Your Ref: OWPC21059
Our Ref: K/40/18/PL 14-11-2018
Please ask for:
Mrs A Gardner

Demolition of existing dwelling & erection of 1 No. dwelling, associated landscaping & parking (resubmission following K/11/16/PL).

Spring Tide Gorse Avenue East Preston

Thank you for your internet representation made on 10th January 2019 which has been recorded as '**an objection**' with the comments as follows:

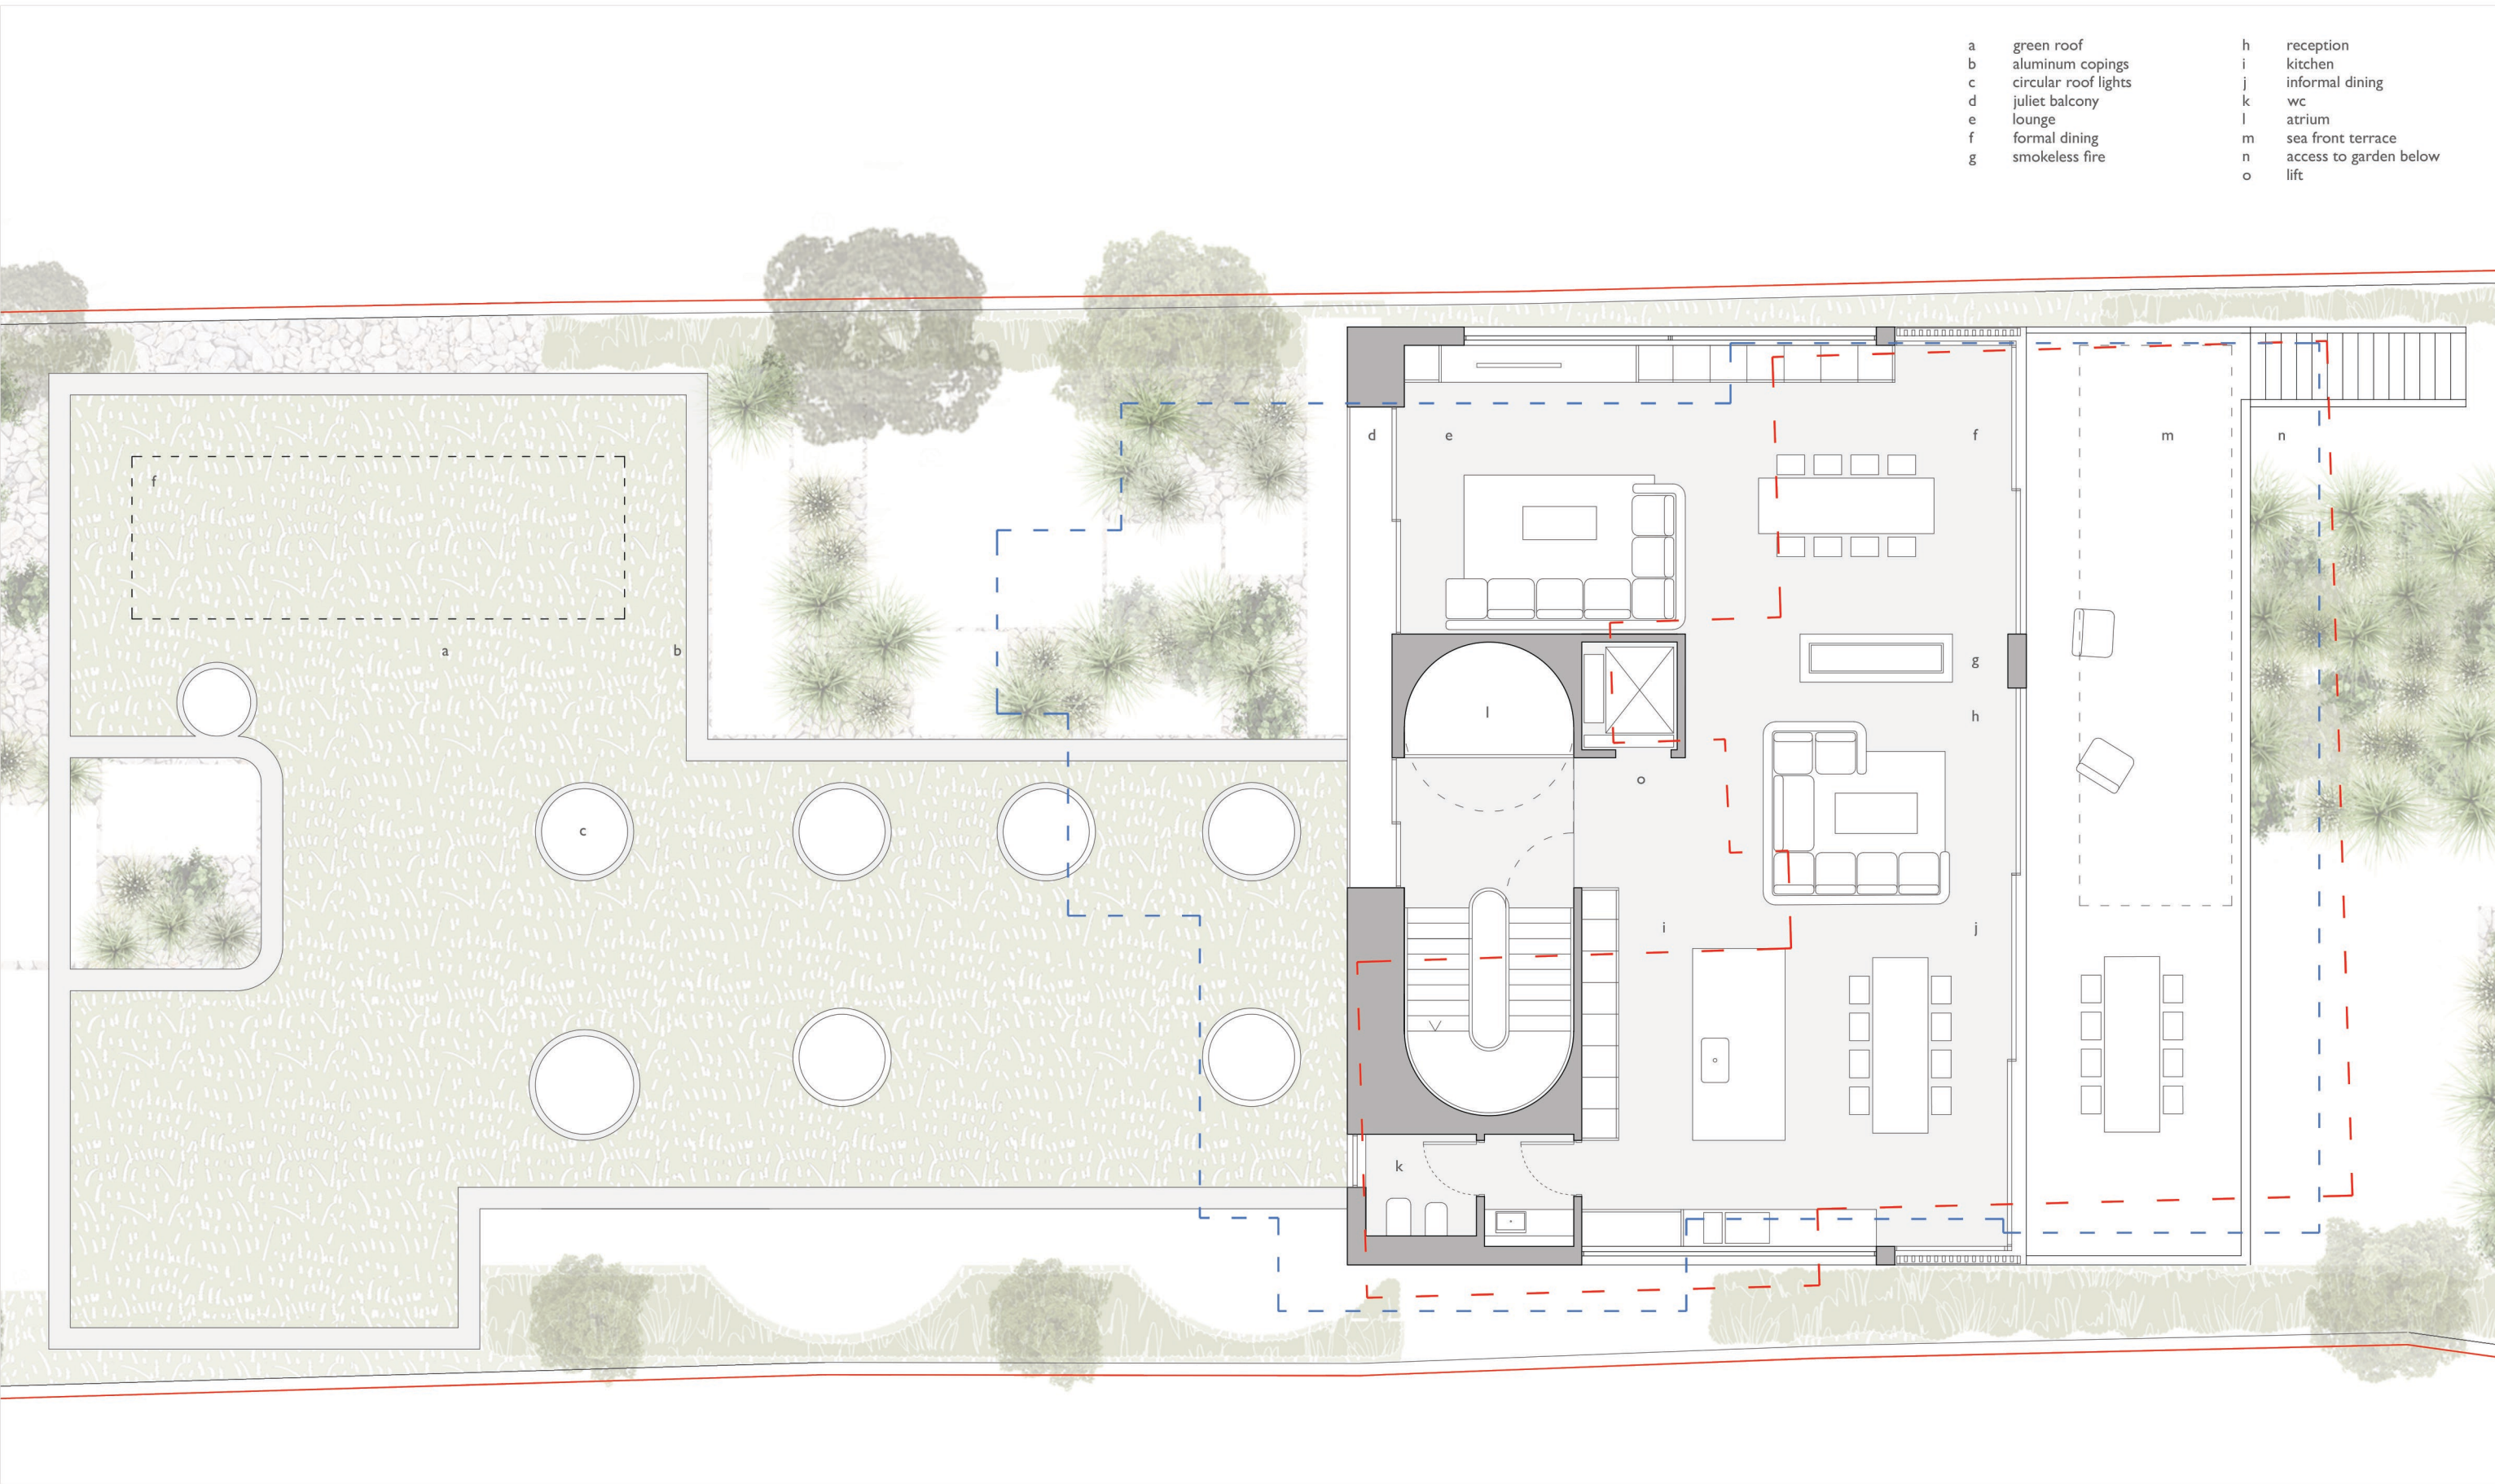
3. The position and design of the house, with balconies on the east, south and west sides of the first and second storeys and a large window on the west side of the first storey, would ensure that the gardens and south facing windows of houses to the west would be overlooked. The design would contravene D DM1 3 of the Arun Local Plan and EPNP 7.1 (iv) of the Kingston Neighbourhood Plan.

Drawing: Proposed Roof Plan
Dwg No: 247-D-10

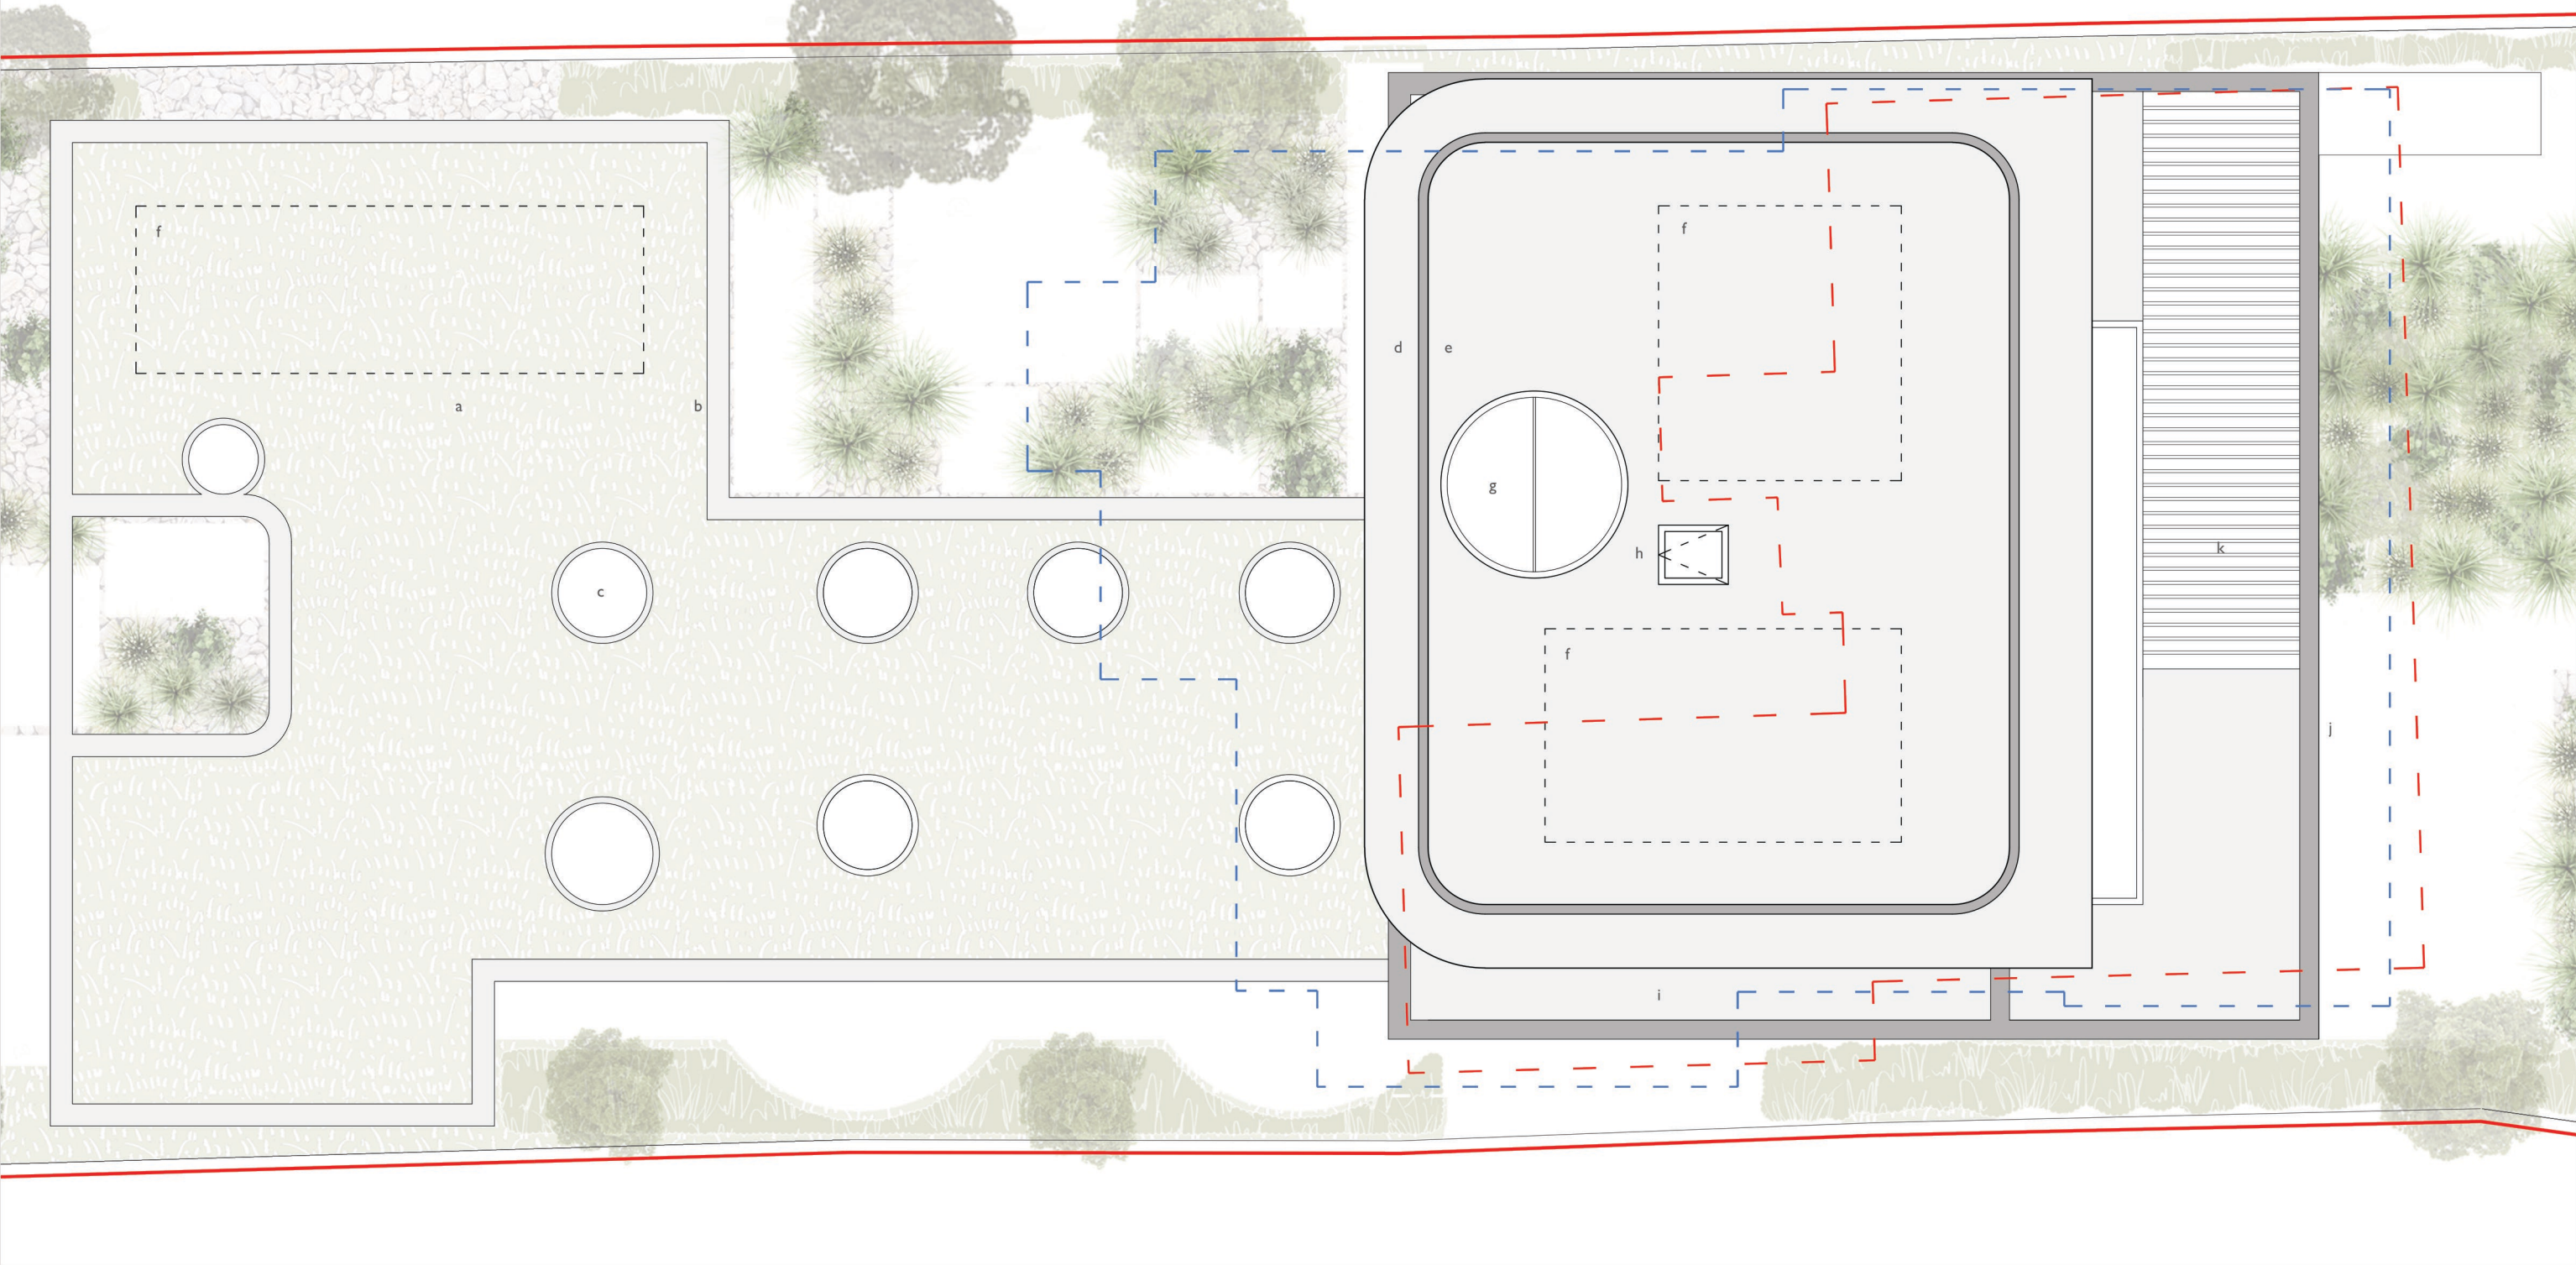
2. The house would be of three storeys and positioned ahead of the neighbouring houses fronting the greensward and the beach. This aspect of the houses is the one most seen by the public. Its uncomprisingly modern design, with a flat roof, projecting balconies and walls that are mostly glass would be extremely prominent and incompatible with that of its neighbours, which are typical of the 1920s and 1930s. It would therefore contravene Policy D DM1 of the Arun Local Plan and policy EPNP 7.1(i) of the Kingston Neighbourhood Plan. The most relevant provision of D DM1 is in paragraph 13.2.7, which states "Therefore successful development should respond to locally distinctive patterns of development, building methods and detailing, materials, history, landscape and culture, or where this is absent, use strong ideas absorbed from contemporary society and culture". Kingston Gorse possesses a strong local pattern of development, and new development in the area should reflect this character. There is no case for building an innovative design in this location.
